## Century Tire

I realized I never circled back on comments on the sidewalk plan for Kennebec. I did get comments from Bruce Hyman. These are below.

CROSSWALK STRIPING DETAIL

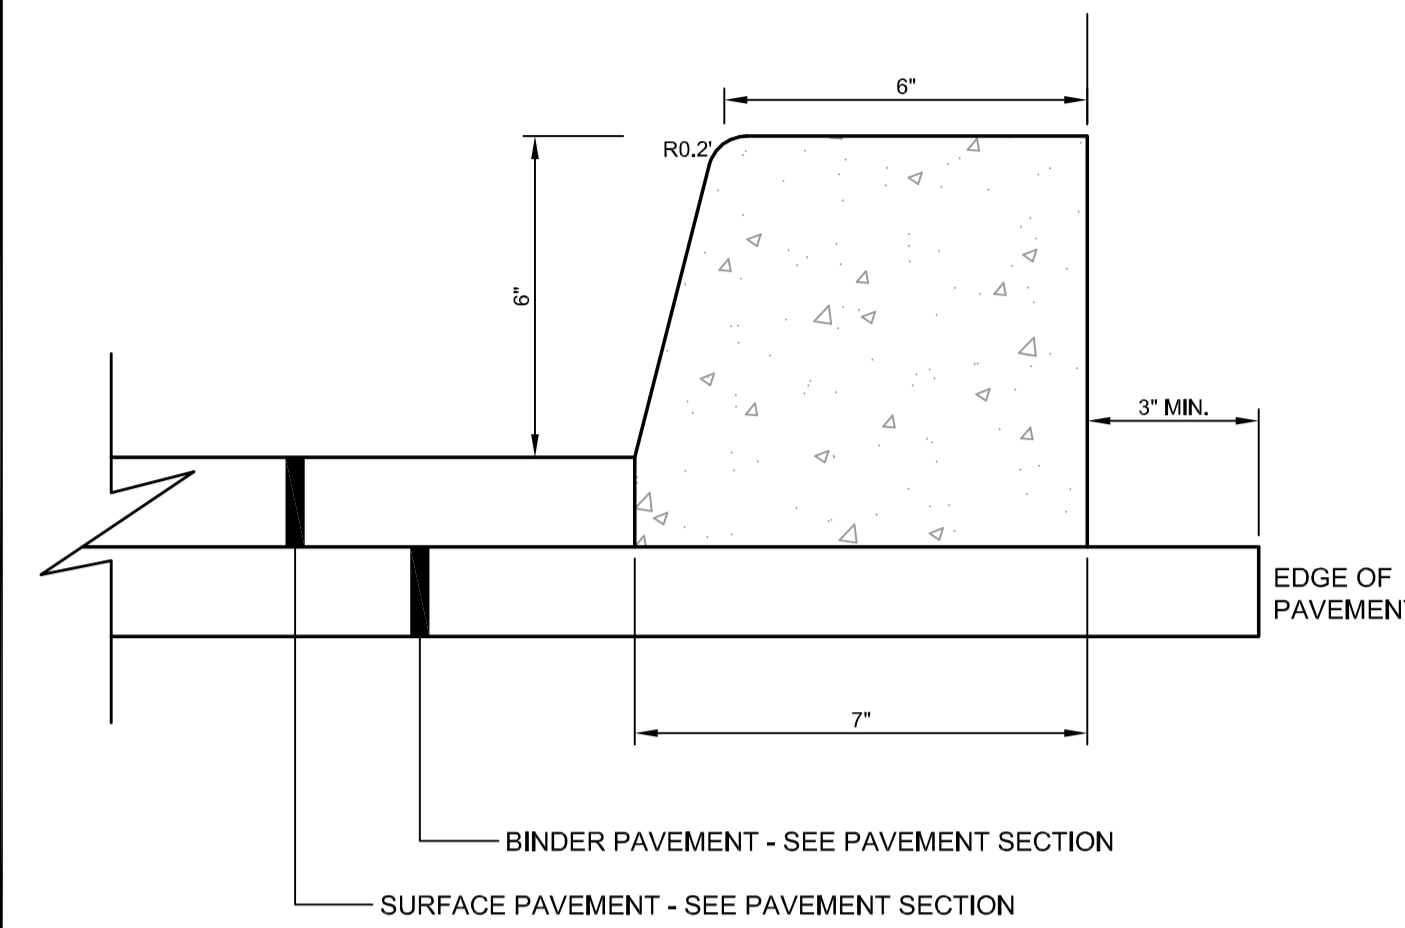
The only other comment is that I believe the crosswalk marking on Kennebec doesn't meet the Technical Manual spec. (See Figure I-22, or even the approved site plan, for the preferred design).
